KITTITAS COUNTY

MEMORANDUM

TO: Jeff Watson, Community Development Services
FROM: Christina Wollman, Planner II *CW*
DATE: February 17, 2011
SUBJECT: Hundley SG-08-00032

PROPOSED

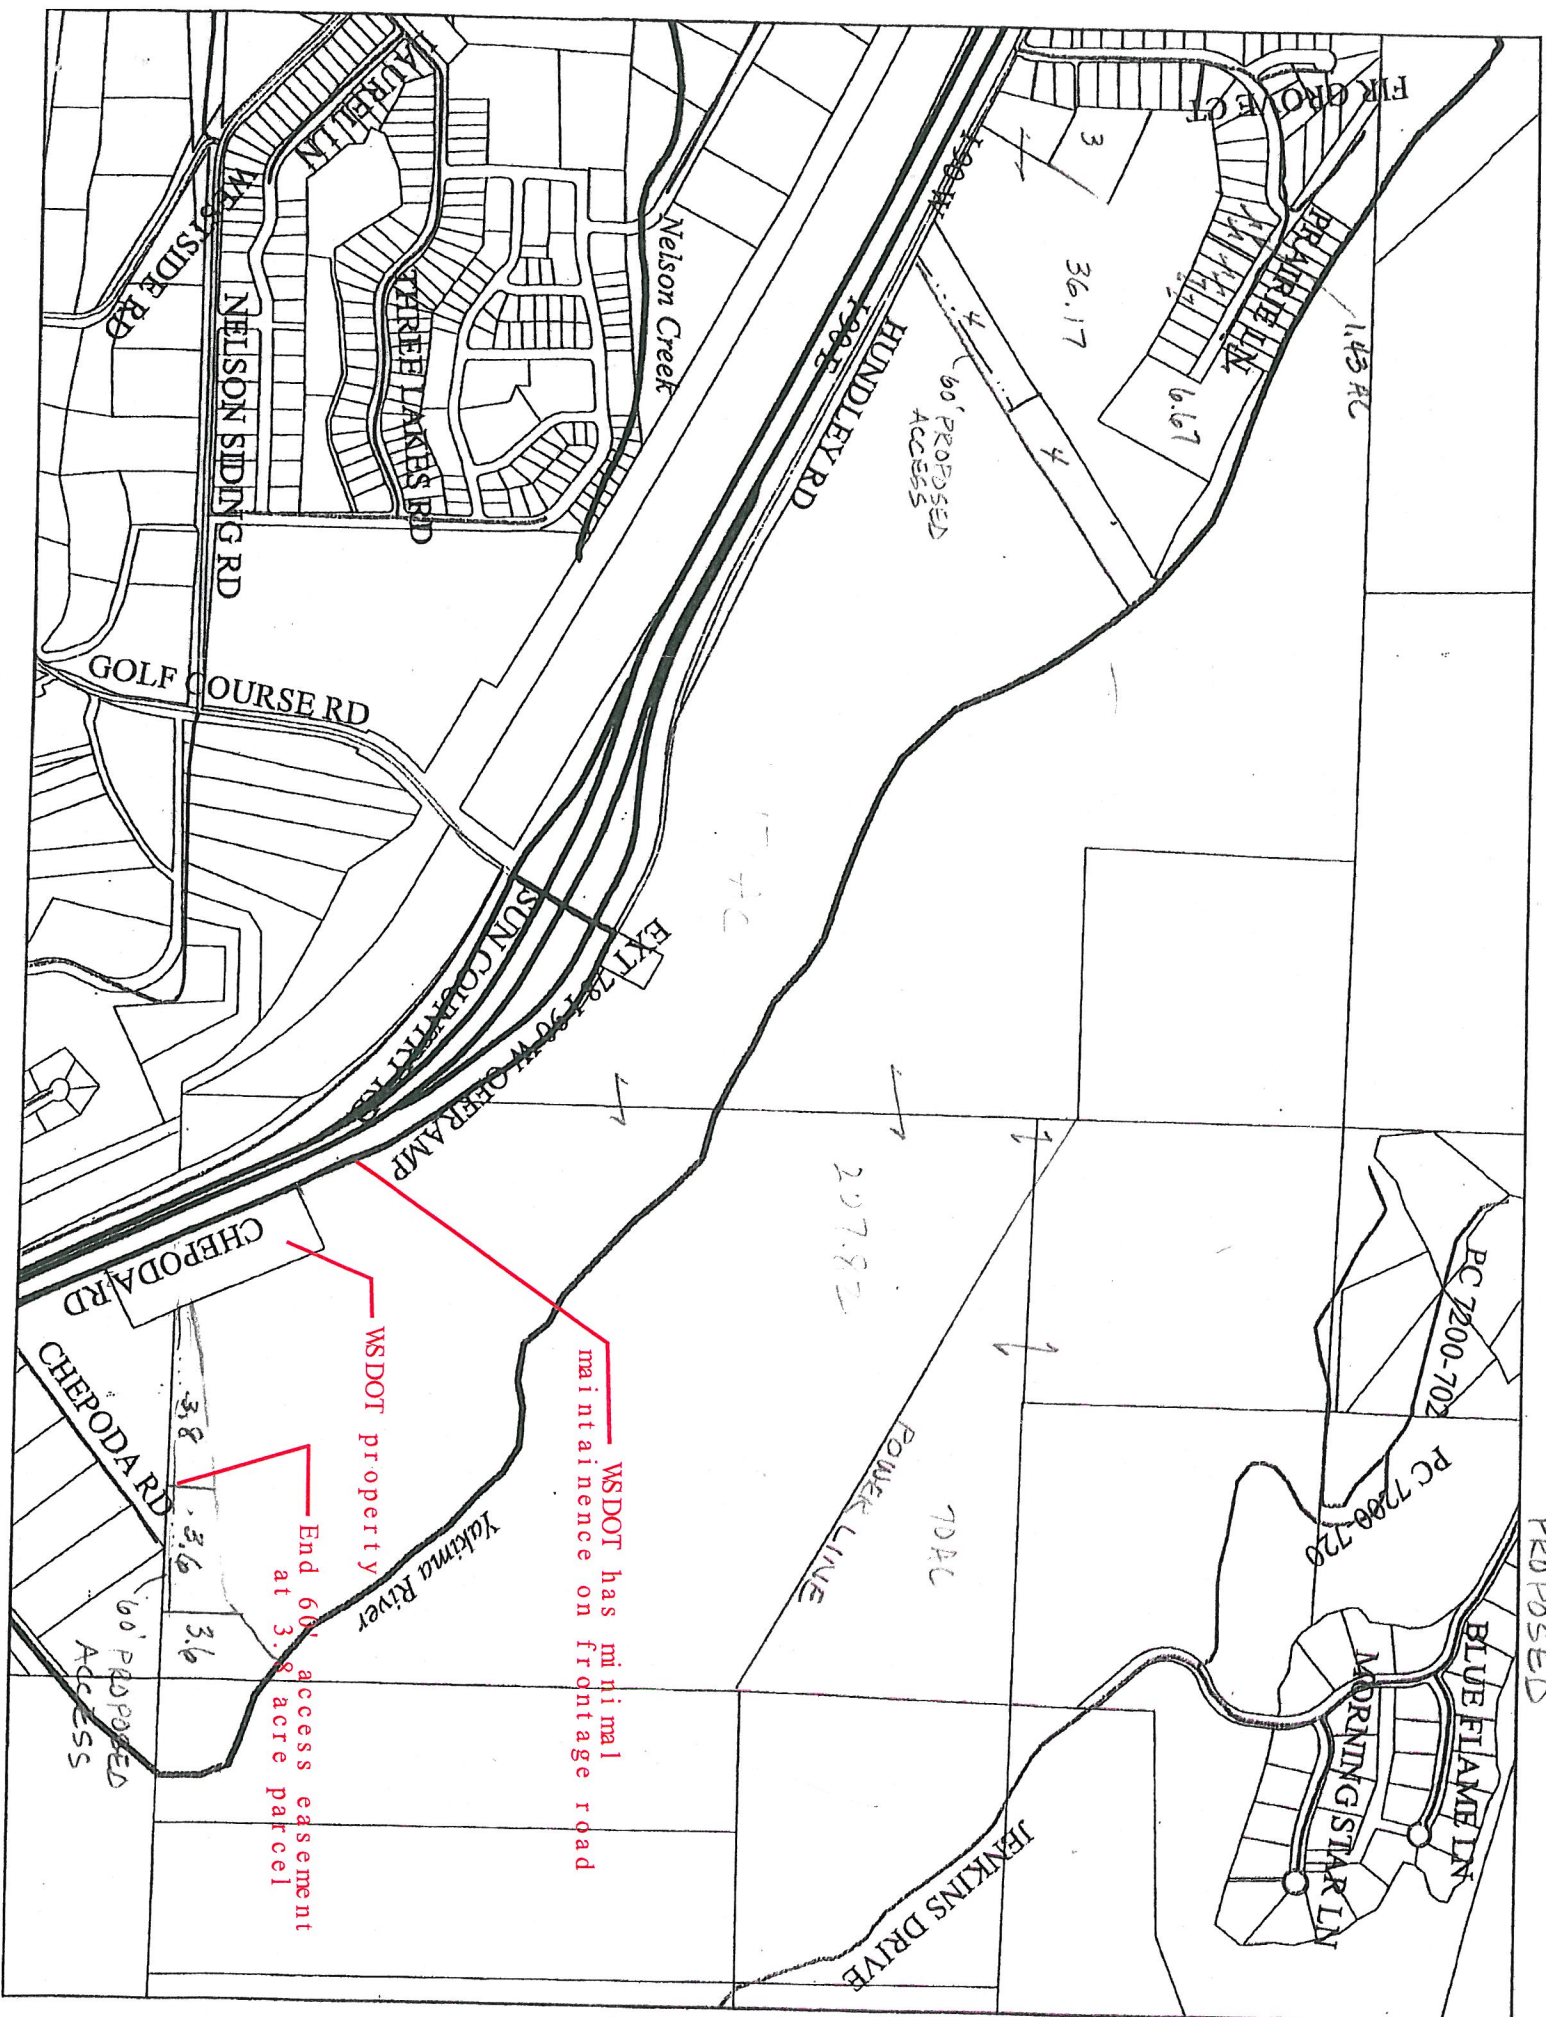
2. The 60' proposed access shown at the end of identified "Chepoda Road" must terminate at the 3.8 acre parcel, and not extend to the rectangular shaped parcel to the west that is owned by the WSDOT (see attachment). No access across this parcel owned by the WSDOT, or the haul road, will be allowed.
